Ref: 6/2021/0557/LB
Date: 10/04/2021

HISTORIC BUILDINGS AND CONSERVATION ADVICE

RE: *Eight Bells, 2 Park Street, Hatfield, AL9 5AX*

- C ONE x new signwritten mural.
- C1 Size 3.48m x 2.46m H.A.G 4.5m
- C2 Strapline size 3.8m x 252mm. H.A.G 3.3m

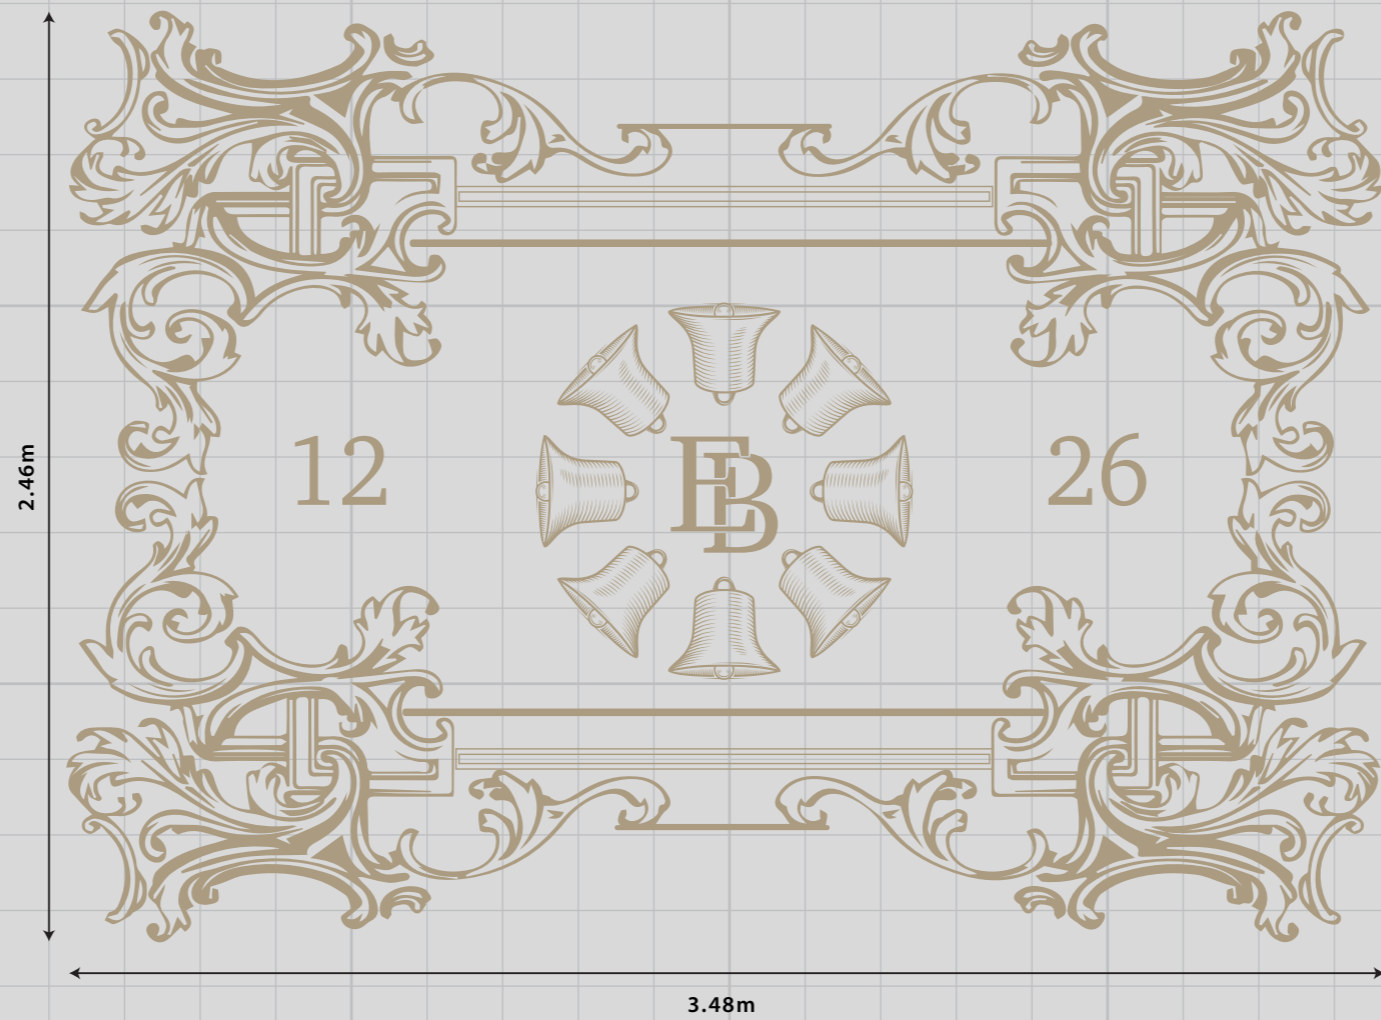
Sign C – This sign, although painted, is considered to be too large and prominent on this elevation of the building. It is also unknown whether 1226 is an accurate date for the establishment of the pub and whether it was in this location (in a former building) so it is recommended that this is omitted. It is also recommended that the “a historic 17th century coaching inn” is omitted as the sign is large and in a prominent position, detracting from this elevation. Advertising the history of the building on the panel sign (Sign D) is supported, but a large painted statement is not considered to be in keeping. The brickwork on this part of the building was historically unpainted. The sign will also detract from the wider streetscape, particularly along Fore Street which is lined with listed buildings and retains its historic character.

A ONE x new fascia with 10mm bevelled perspex letters, illuminated by trough light.  
Size 4.8m x 500mm. H.A.G 2.5m

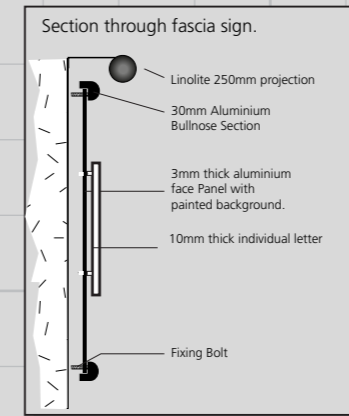
Sign A – There are no objections to its replacement, however, this should be a painted timber board not aluminium. As noted above, the existing sign may not benefit from listed building consent and the use of a modern material is not appropriate for a traditional building. The repositioning of the trough light so it does not overhang the sign is supported.
